FROM: Ian Gledhill TO: Arun District Council
FAO: David Easton

SUBJECT: P/6/17/OUT - Outline application with some matters reserved for construction of up to 300 No. new homes, Care home of up to 80 No. beds, D1 uses of up to 4000 sqm including a 2 form entry Primary School, formation of new means of access onto Hook Lane & Pagham Road, new pedestrian & cycle links, the laying out of open space, new strategic landscaping, habitat creation, drainage features & associated ground works & infrastructure. This application is a Departure from the development plan.

Land North of, Hook Lane, Pagham, West Sussex

A	Tactile Paving adjusted & Hook Lane South Access removed	13/03/17	MRA	BRP
Rev	Description	Date	Initial	Checked

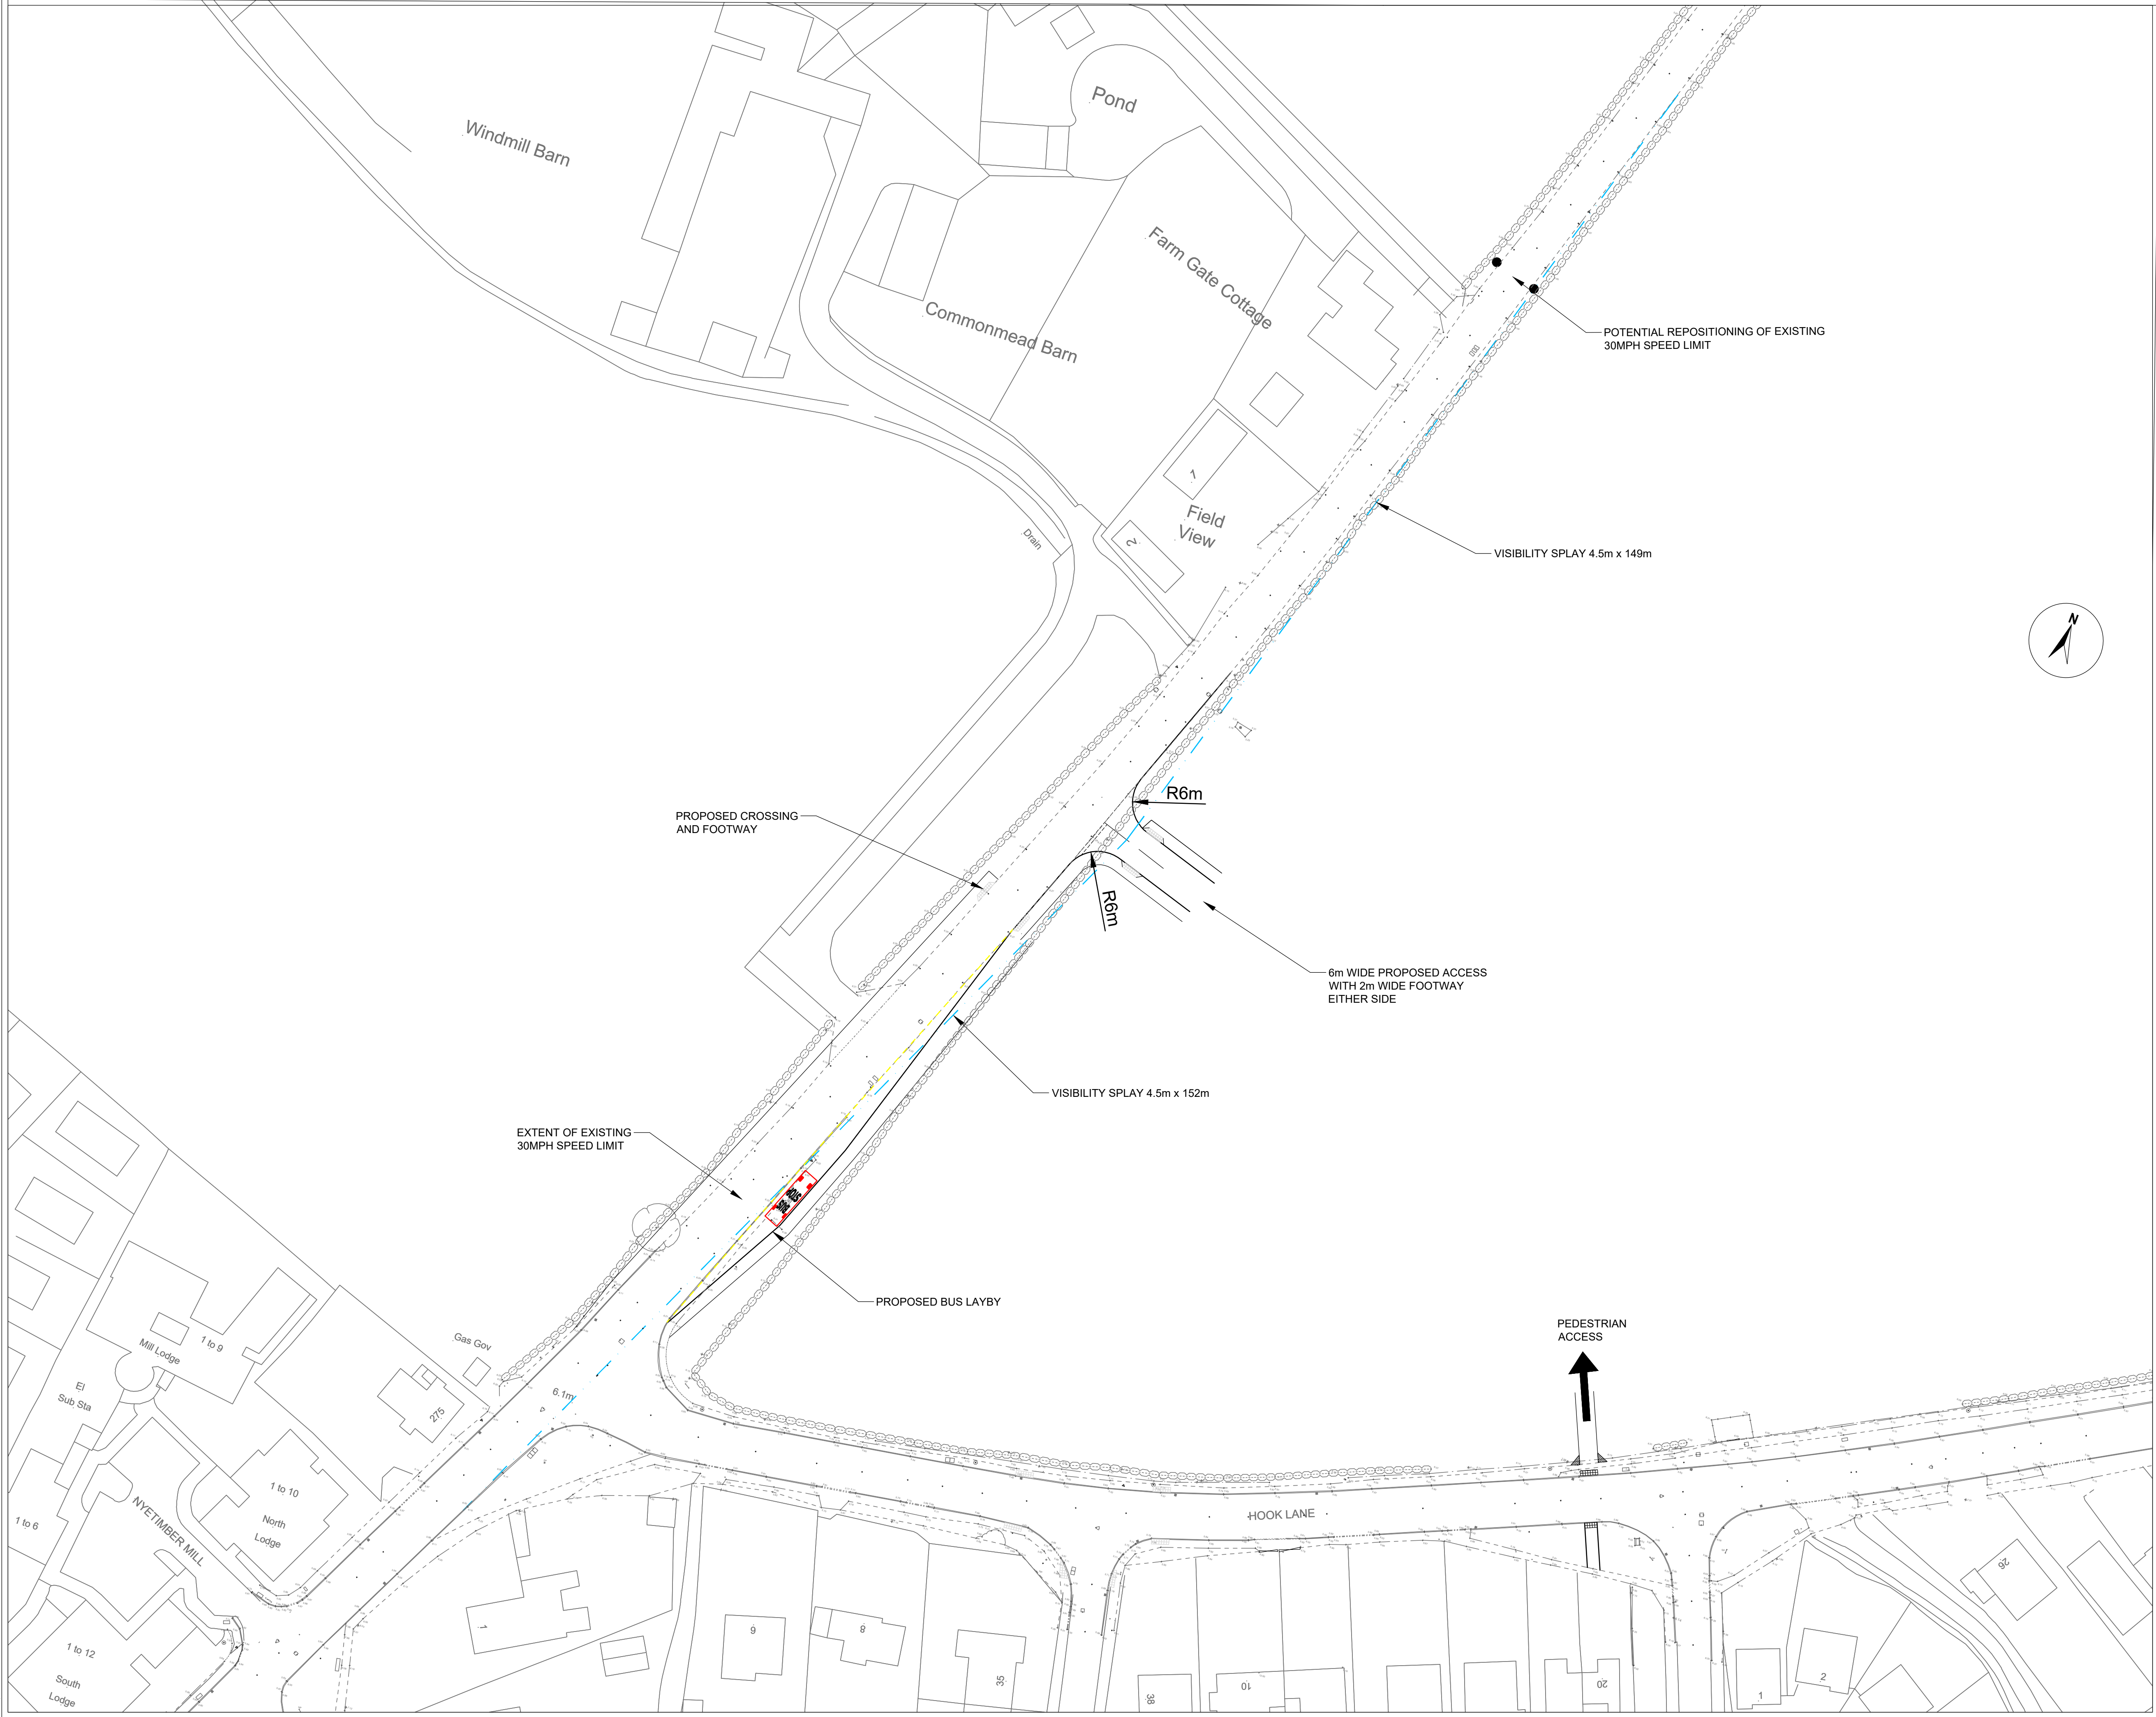
4. Plans initially submitted indicated the provision of two vehicular accesses onto Hook Lane on the proviso that a school site was provided as part of the development. As there was uncertainty as to whether this site would be required to provide a school, it was unclear whether the 2nd Hook Lane access was to form part of this development; clearly as the current application seeks outline approval with matters of access to be approved, this matter would need to be determined now. This matter has been addressed with the 2nd and more southerly Hook Lane access being omitted (this is shown on the Development Framework Plan, revision E).

5. A number of points were made in connection with the proposed Pagham Road access, namely whether the form of junction shown (a priority junction with right turning lane) was necessary in safety or capacity terms given the extremely low number of right turning movements. The design (as shown on drawing number JNY8840-12 Rev A) has been altered with the right turning lane removed.

6. As required by the LHA, the revised design has been passed to the Safety Auditor who reviewed the original highway works designs. They have raised no safety problems with the revised scheme. The removal of the right turning lane also satisfies and overcomes a problem raised within the initial Stage One RSA (this being that the right turning lane may be used for overtaking). There are still other detailed matters raised by the Auditor that should be accounted for as part of the detailed design.

7. Two other matters were raised by the LHA in connection with the design of this access; the presence of a pedestrian refuge and the proposed bus stop lay-by. As the right turning lane has been removed, the pedestrian refuge has also been taken out of the design. This matter is consequently addressed.

8. The bus stop lay-by remains part of the scheme design. This is located so as to be outside the visibility splay for the proposed junction. Vehicles stopped within this would consequently not obstruct visibility for emerging vehicles. Vehicles within the lay-by may affect visibility northwards from the Hook Lane junction. However as the bus stop is existing, vehicles stopped at this already have the potential to impact on visibility. The presence of a lay-by if anything would if anything offer a betterment by ensuring that the stationary vehicle is located to the back of the visibility splay, thus lessen the overall impact.

No use within that phase of the development served from the Pagham Road access shall be first occupied until such time as the vehicular, pedestrian accesses and bus stop lay by have been constructed in accordance with the details shown on drawing number JNY8840-12 Revision A and provided with visibility splays of 4.5 by 149 metres to the north and 152 metres to the south. Once provided the splays shall thereafter be maintained and kept free of all obstructions over a height of 0.6 metre above adjoining carriageway level or as otherwise agreed.
